RE: Volcano Cliffs Subdivision Lot 1, Block 8, Unit 18 6512 Papagayo Rd. NW
Grading and Drainage Plan
Engineers Stamp Date 1/30/17 (D10D003O1)

Based upon the information provided in your submittal received 1/17/17, the above referenced Grading and Drainage plan dated 1/17/17

GRADING & DRAINAGE PLAN 6512 Papagayo Road, NW LOT 1, BLOCK 8, UNIT 18 VCS

GRADING AND DRAINAGE PLAN
LOT 1, BLOCK 8, UNIT 18, VCS
ADDRESS: 6512 Papagayo Rd NW

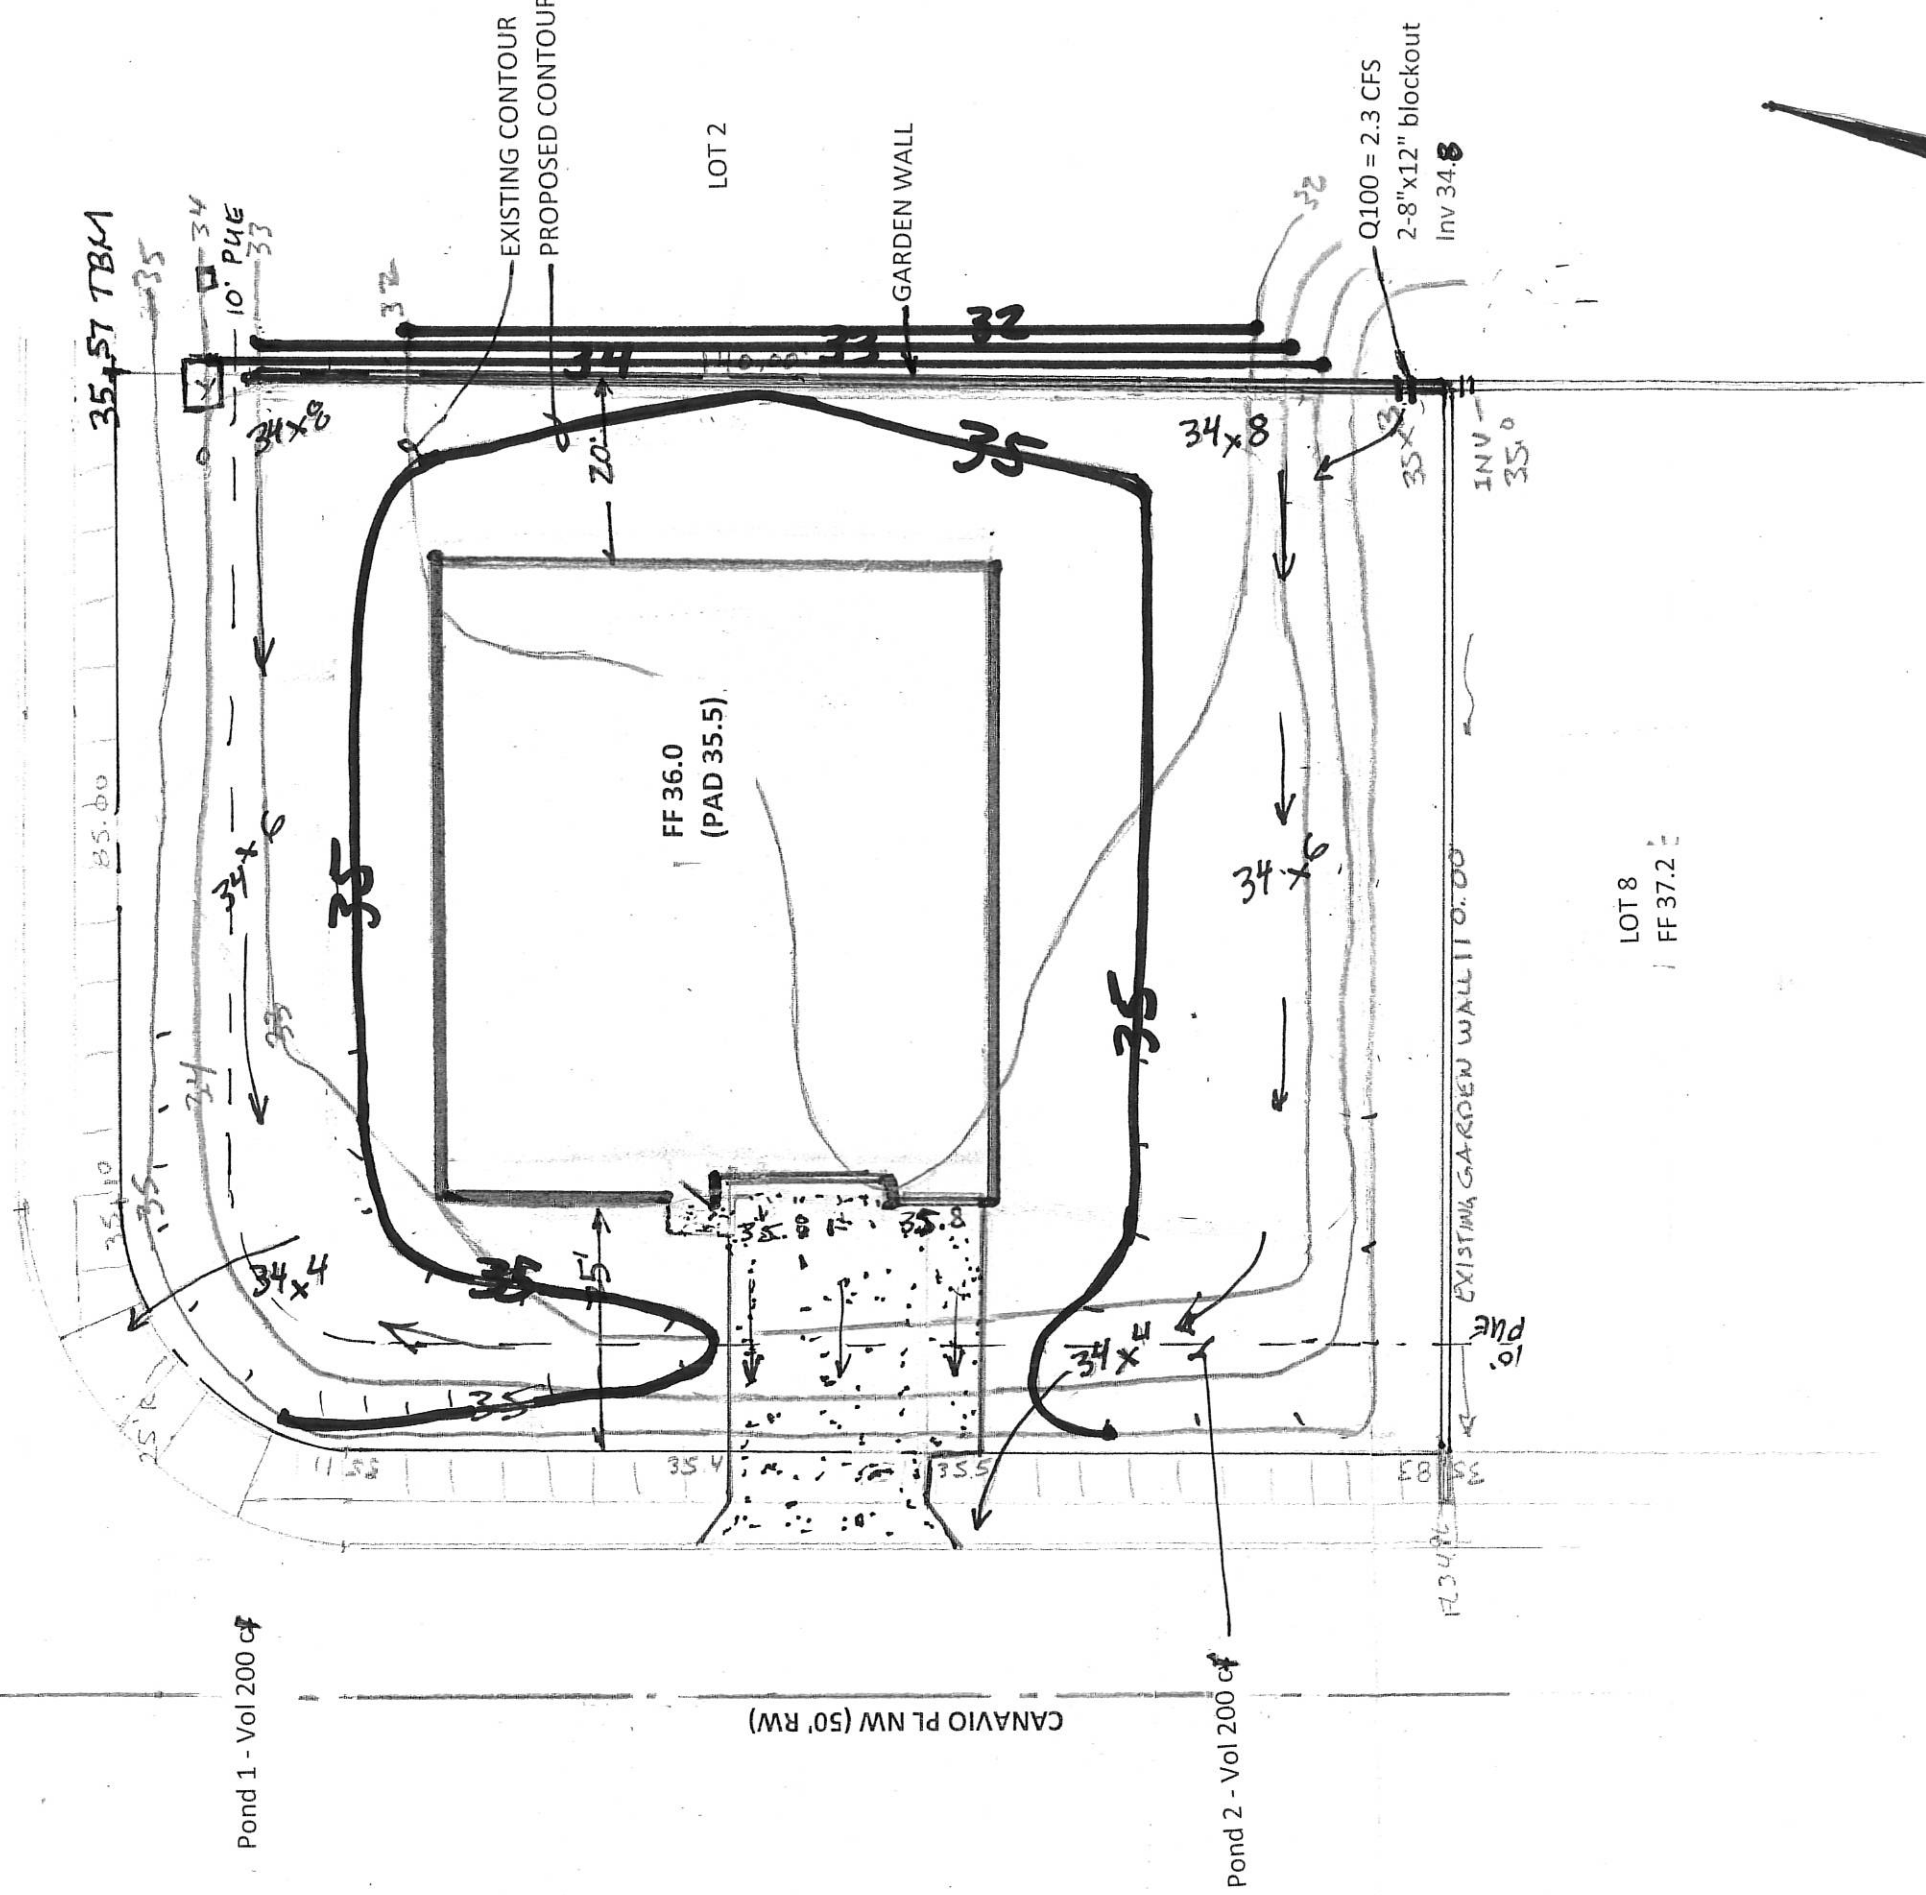
- Provide a note stating that future garden walls require a separate permit and this plan should be used for their placement.
- Also state that future garden walls require an opening 3" above grade in the SW corner.
- Provide a statement that a pad certification is required before a building permit is given.

1. Future garden walls require a separate permit and this plan should be used for their placement.

2. Future garden walls require an opening 3" above grade in the SW corner.

3. A pad certification is required before a building permit is given.
